Application: Erection of two industrial units for light industrial processes (E(g)(iii)) / general industrial (B2) / storage & distribution purposes (B8) and ancillary office space, with associated parking, access and supporting infrastructure.

Address: Plot 5610 Gypsy Moth Avenue Hatfield AL10 9BS

Application No: [6/2022/2759/FULL](#)

ECOLOGICAL IMPLICATIONS

22.034 Cambria. Plot 5610 Hatfield_ External Lighting 221128

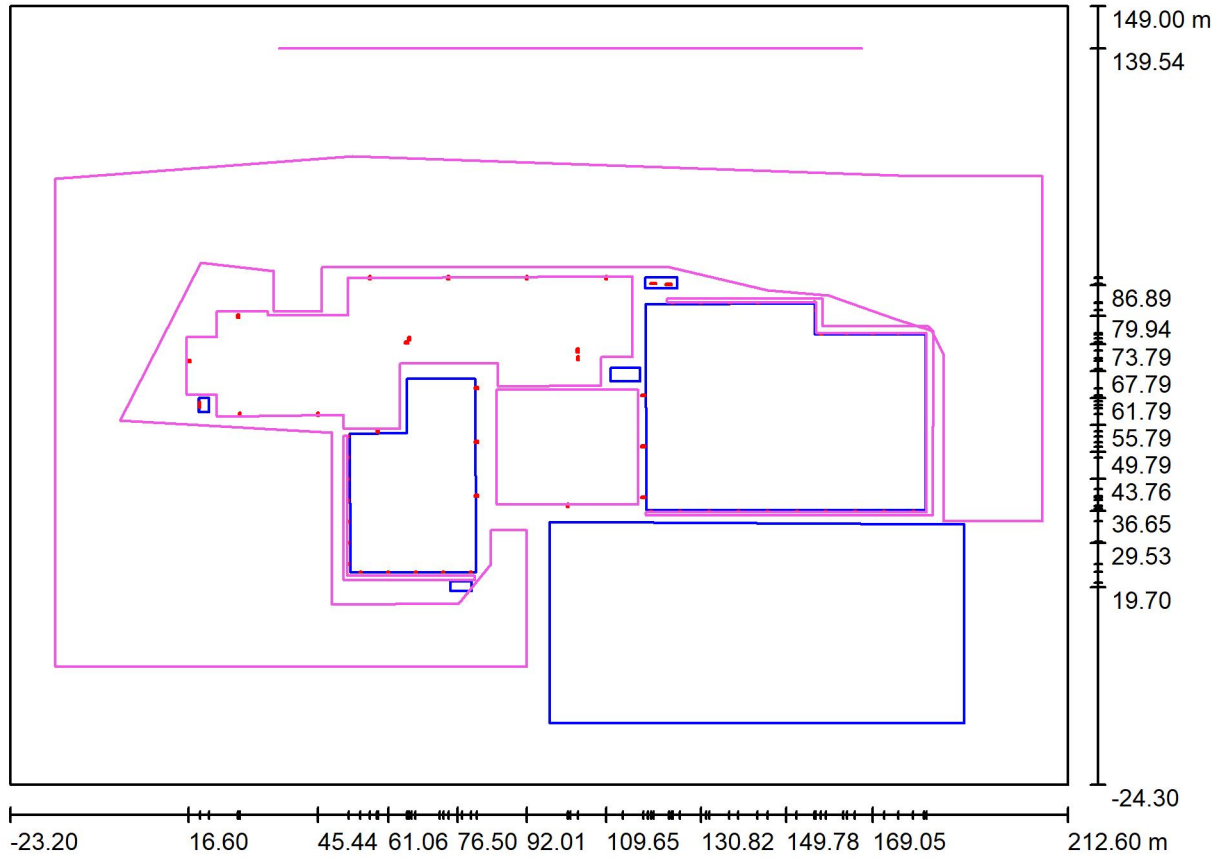
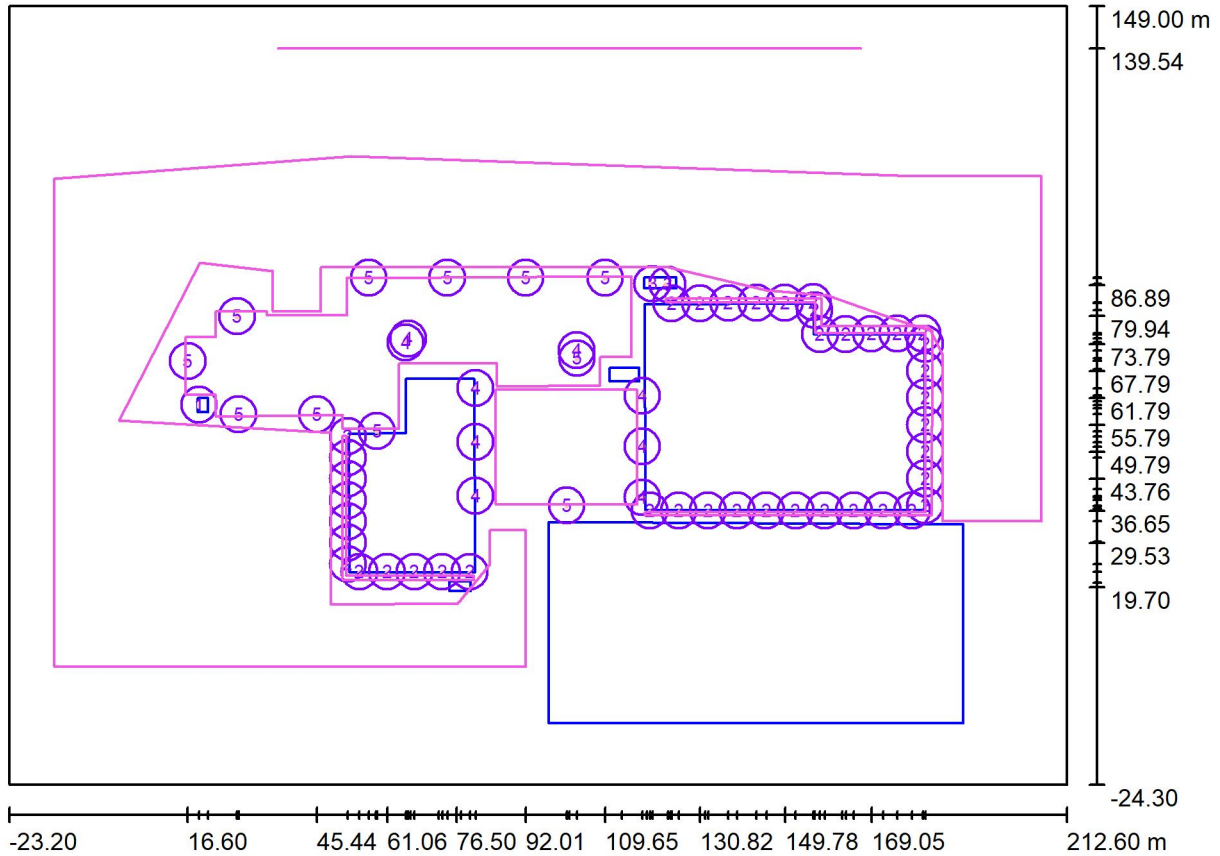
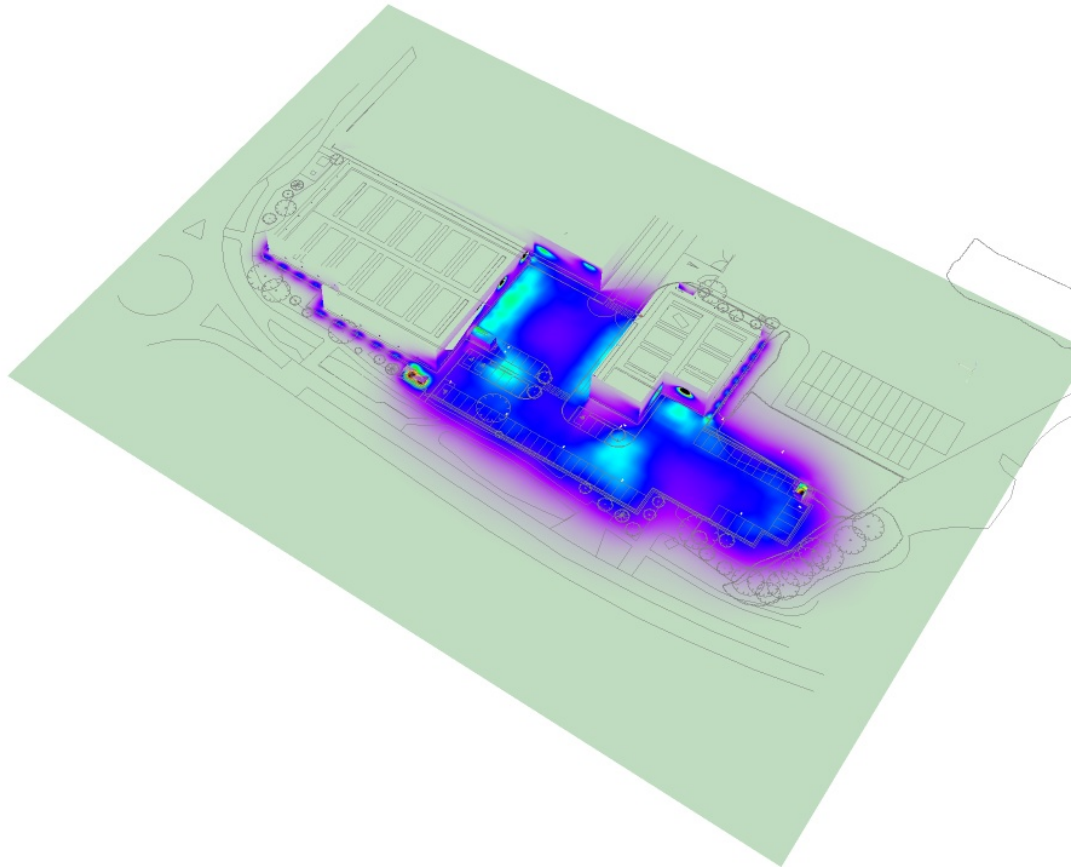
An External Lighting Plan has been submitted. This demonstrates that there will be limited impact on the existing tree/shrub belt to the west of the site, the most significant feature associated with the site. This reflects due regard to the potential presence of foraging and commuting bats.
